## Development Facilitation Team (DFT) – Review Comments

**Project No: PR-2023-009105 Date: 5/21/2025      Agenda Item: #2 & 3 Zone Atlas Page: B-14**

**Legal Description: 2A, 2B, Cottonwood Crossing Phase 2**

**Request: 3. Major Preliminary Plat Application for 7 Bar Loop containing approximately 3.14 acres.**

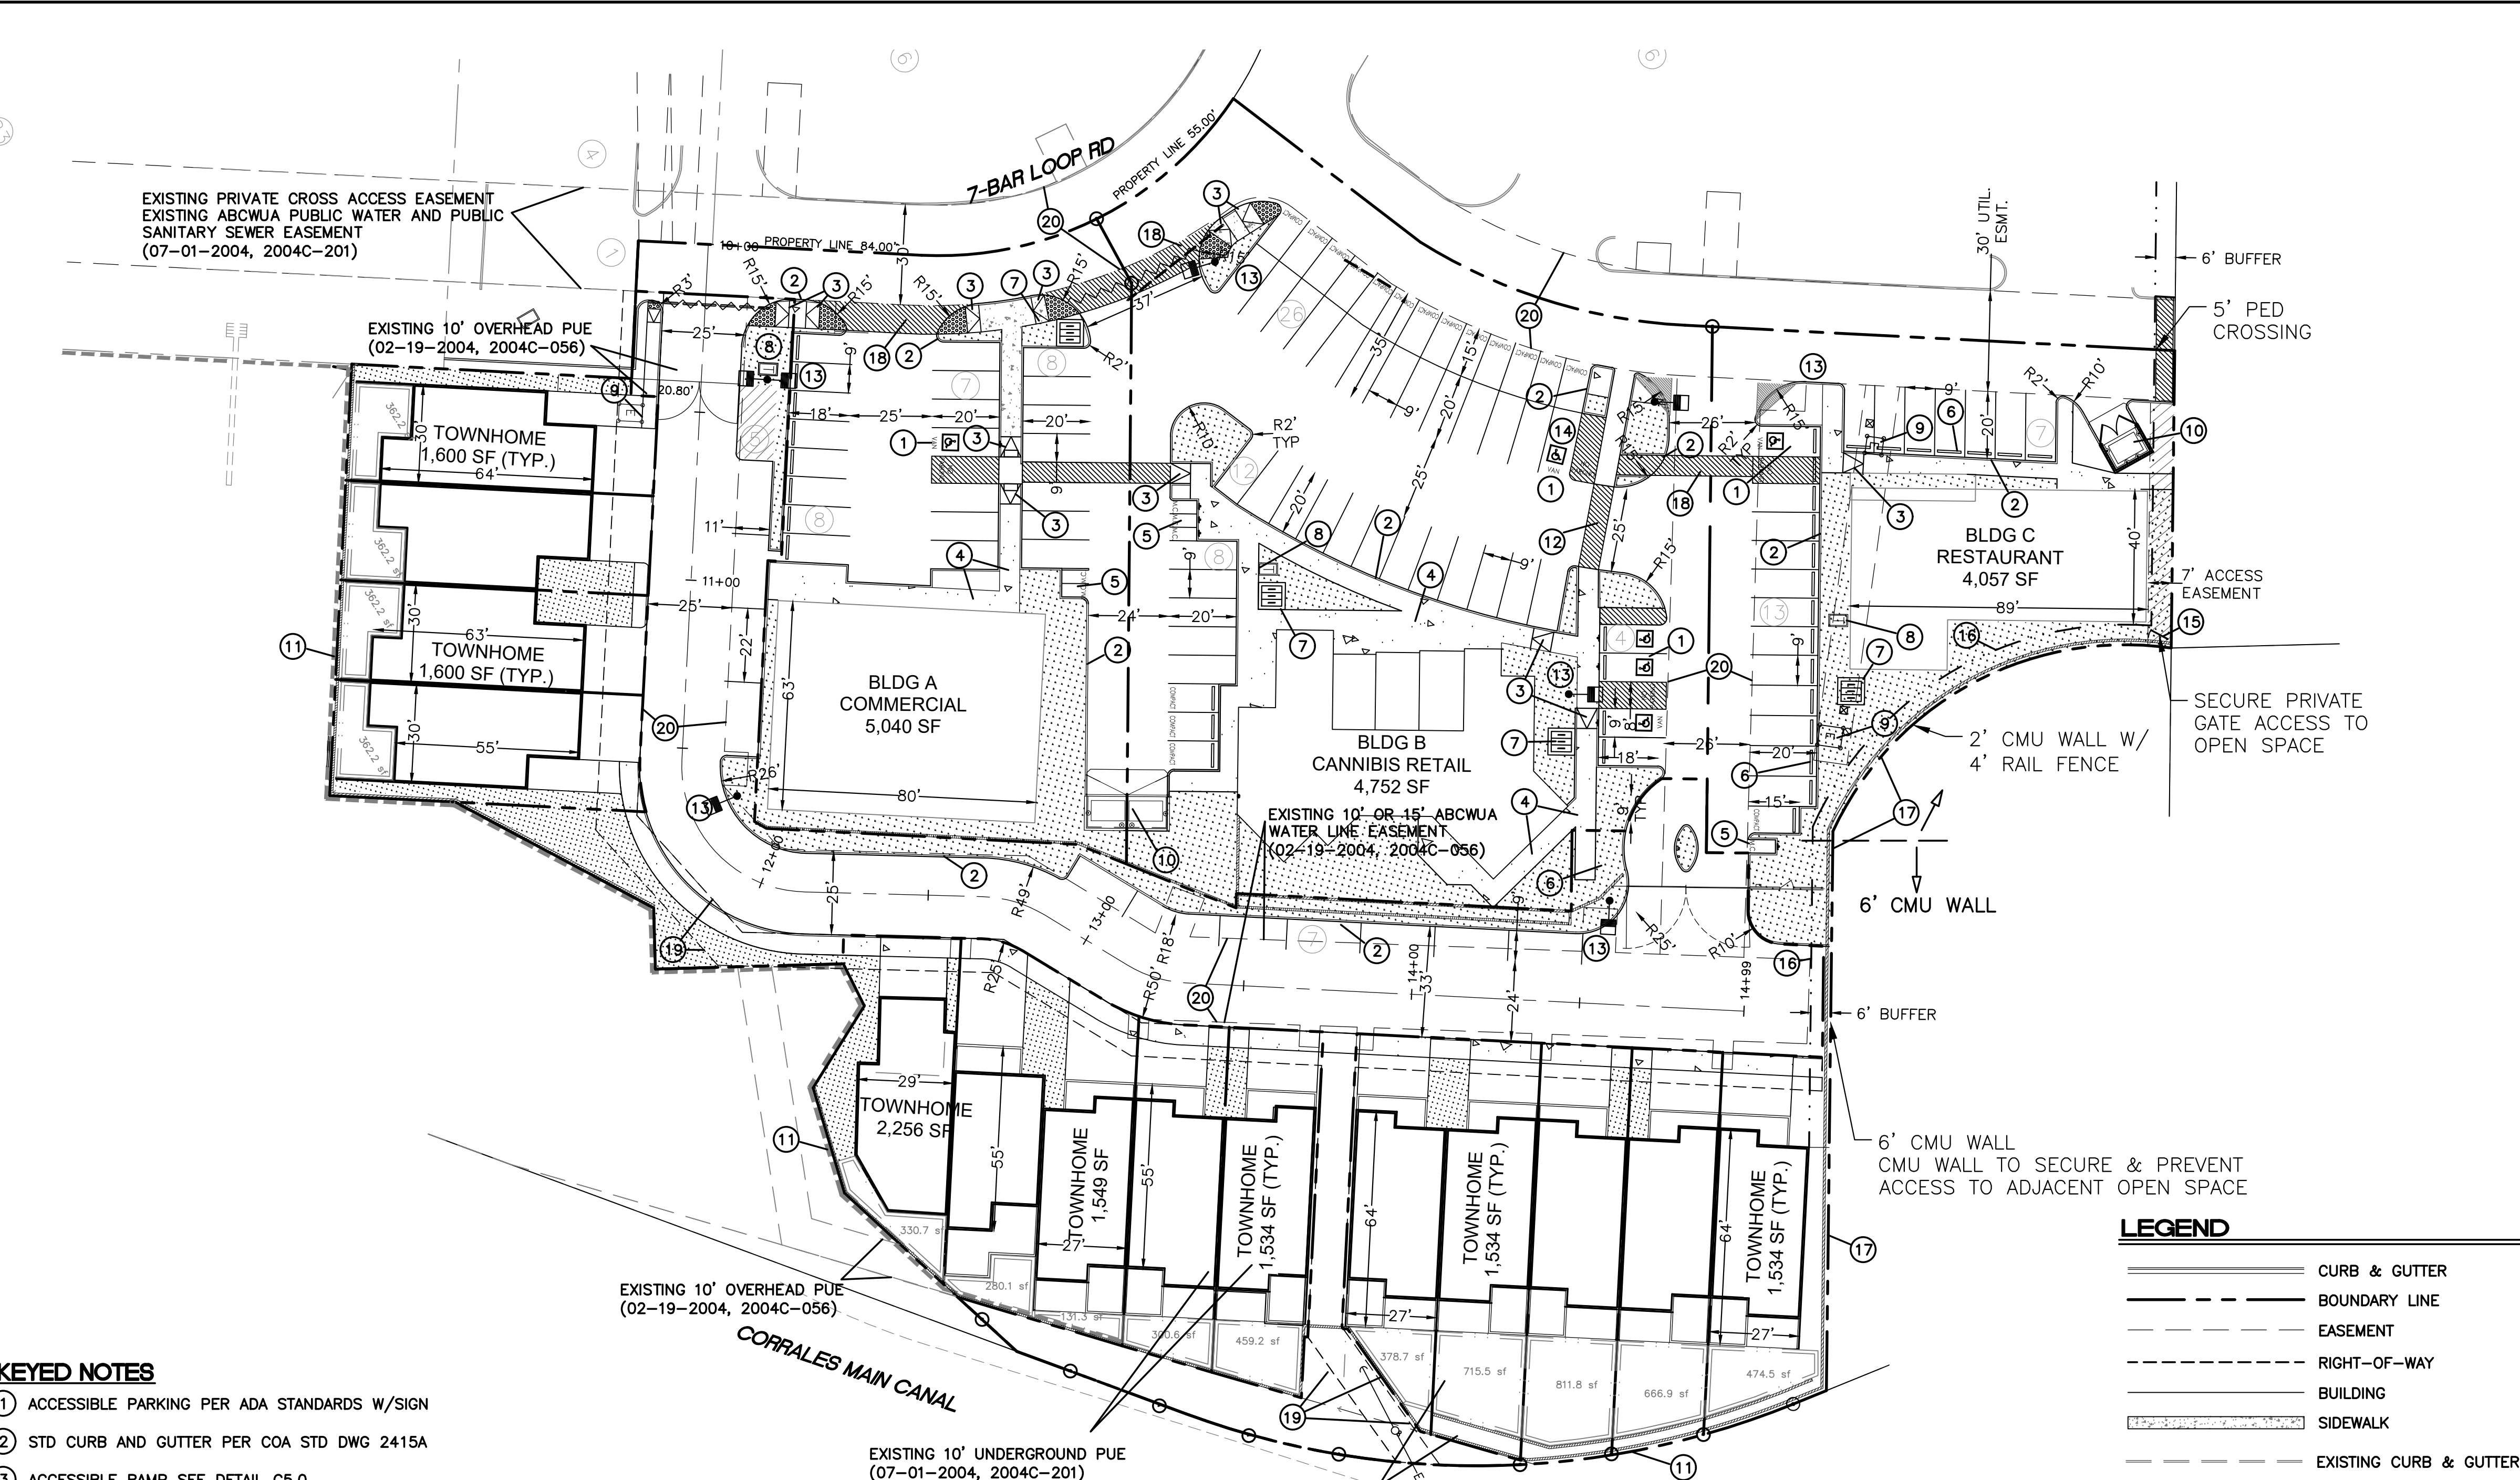
The Open Space Division has concerns regarding PR-2023-009105. After visiting the site recently, the staff noticed a fence was constructed from the MPOS property line, which varies from one to two feet, and major grading has already begun on the property. The OSD provided comments to the EPC, stating that there should be a six-foot buffer and no disturbance within that buffer.

1. Including a proposed 6-foot buffer from the property line along the MPO property line with no building footprints (previously no buffer was proposed). 1. All walls along this property line to be wholly located in this buffer set towards the interior of the developed property to the greatest extent possible on the current site plan. 1. No excavation or disturbance to soil to take place on Open Space land.

3. Agreed to a rail-post combination fence as shown on the latest site plan generally near the radius property line that becomes a solid 6' CMU wall as the property line runs east.

As a condition of approval, the OSD requests assurances that the buffer will be maintained and no further disturbance will be made within the buffer area.

Drawn By:	TA	Date:	01-20-2025
Checked By:	TA	Drawing Name:	22114PL4-5.DWG
Job No.:	22-114	Sheet:	4 of 5

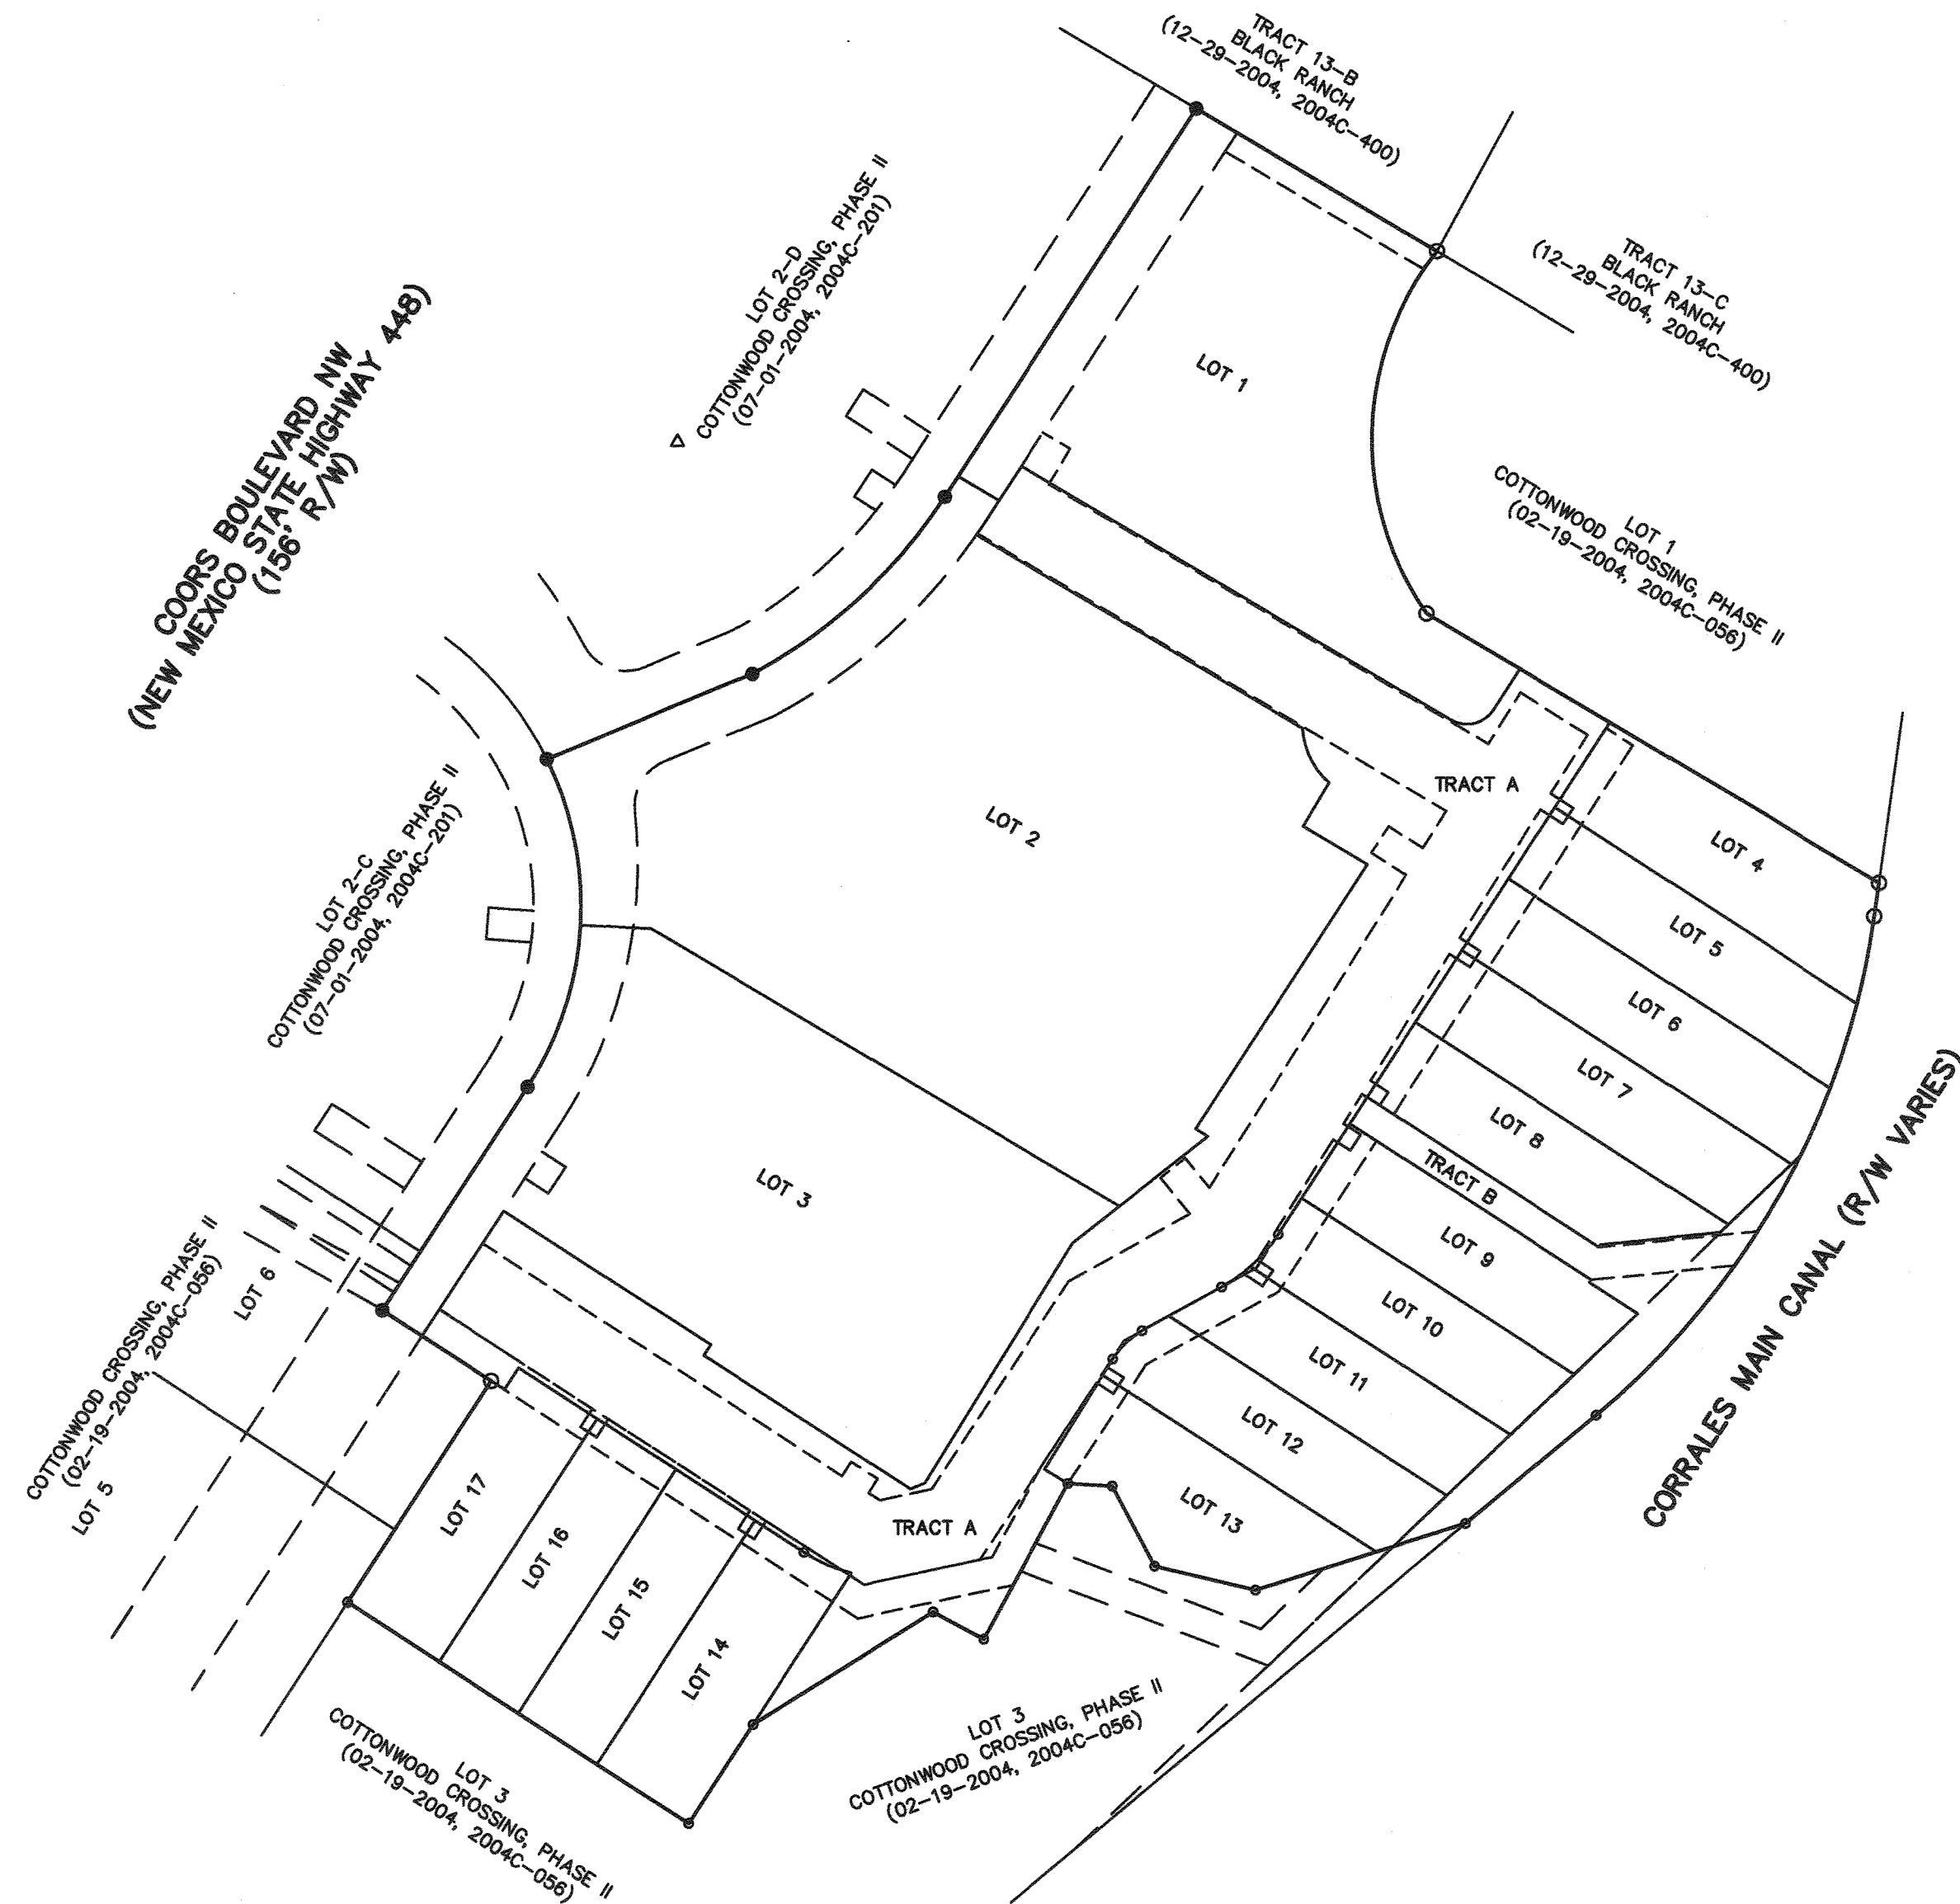
1. Infrastructure List:
  - a. Need to show the boundaries for water and sanitary sewer to agree with what is shown on the plat. (e.g. Townhome Drive is not shown, and Townhome #1 is also not shown)
2. Plat:
  - a. Please move the general easement not for ABCWUA to the cover sheet of the plat.
  - b. Please also grant a public water and public sanitary sewer easement for the necessary infrastructure.
    - i. Please note this needs to be exclusive and as proposed, there is currently a blanket Public Utility Easement noted (dry utilities) on Tract A. Please revise.
